ADDRESS : 655 FLINTLOCK LN
 CONTRACTOR : J & W CUSTOM BUILDERS INC
 OWNER : NC CORRAL LLC
 PARCEL : 05-0624- - -0040- -03-
 APPL NUMBER: 16-50039383 CP NEW RESIDENTIAL (SFD)
 DIRECTIONS : US401NW/ L@ CHRISTIAN LIGHT/ L@ RIVER/
 L@ FLINTLOCK LN/ LOT IS ACROSS STREET
 FROM 634

STRUCTURE: 000 000 2800 SQFT 2BDR W/REC ROOM W/DECK CRAWL

FIELD REPORT

AS REQUESTED, A. TAKLA VISITED THE PROPERTY and OBSERVED THE ROOF TRUSS (Bottom chord was cut at the Attic Access opening)

1 12" CMU GARAGE FOUNDATION WALL

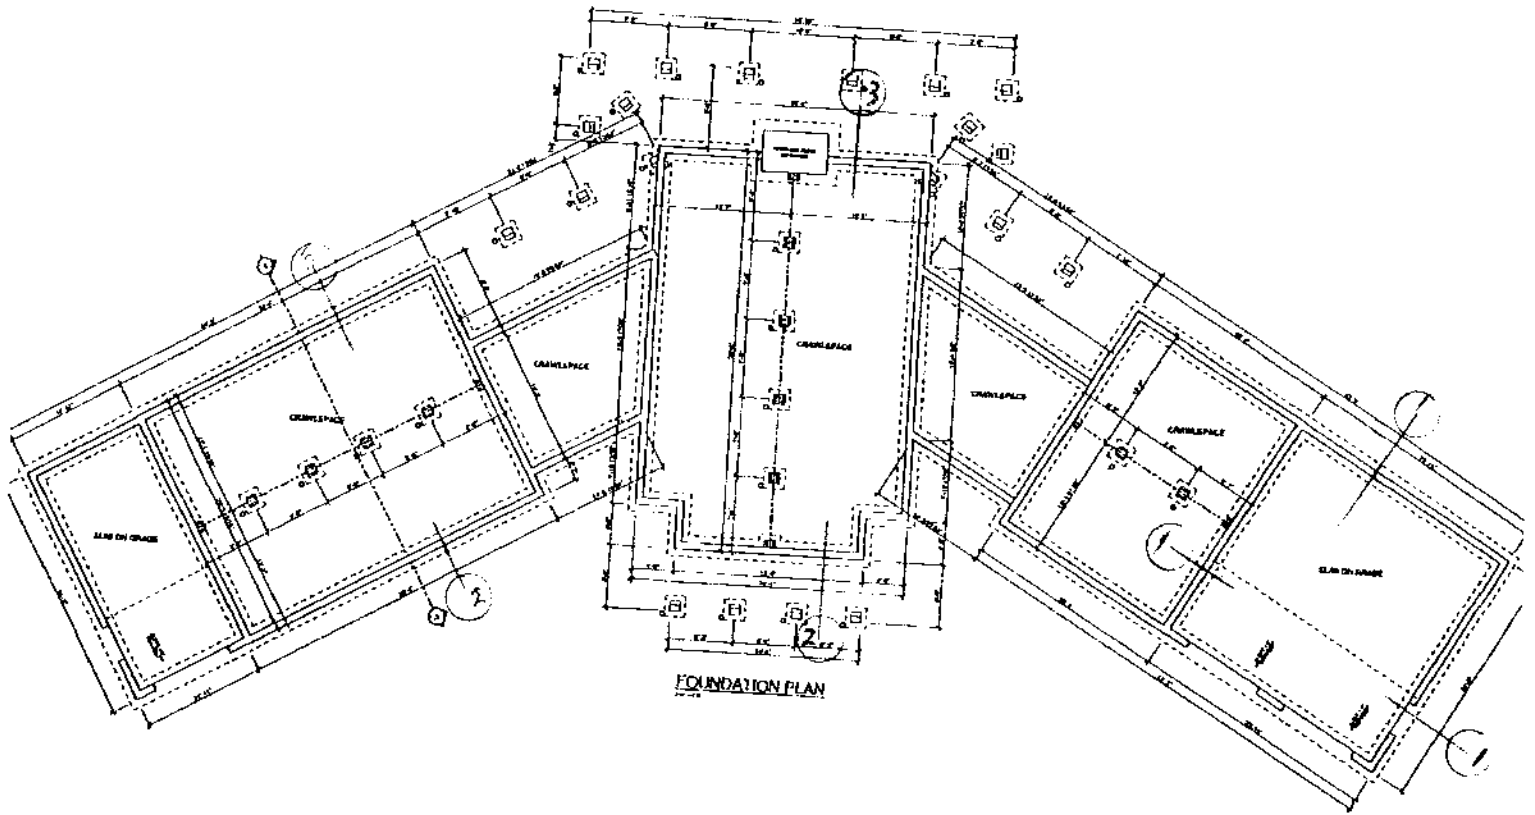
TYP/SQ	REQUESTED COMPLETED	INSP RESULT	DESCRIPTION RESULTS/COMMENTS
B101 01	9/19/16 9/19/16	BS DA	R*BLDG FOOTING / TEMP SVC POLE TIME: 17:00 VRU #: 002872752 T/S: 09/16/2016 09:13 AM JFORBES T/S: September 19, 2016 10:02 AM BSUTTON Engineered plan calls for #4 vertical rebar in all walls above 4 feet high, and all piers in each cell. This must be in place at time of footing inspection. Call to reschedule.
B101 02	9/23/16 9/23/16	BS AP	R*BLDG FOOTING / TEMP SVC POLE TIME: 17:00 VRU #: 002875524 T/S: 09/22/2016 12:13 PM LBENNETT T/S: 11/15/2016 09:33 AM DJOHNSON
A814 01	12/01/16 12/01/16	SB AP	ADDRESS CONFIRMATION TIME: 17:00 VRU #: 002904878 655 FLINTLOCK LN FUQUAY VARINA 27526 POST ADDRESS AT LONG DRIVE WAY T/S: 12/01/2016 09:31 AM SBENNETT
B103 01	12/02/16 12/02/16	BS AP	R*BLDG FOUND & TEMP SVC POLE TIME: 17:00 VRU #: 002905784 T/S: 12/01/2016 01:40 PM JFORBES T/S: December 02, 2016 09:17 AM BSUTTON Engineering attached
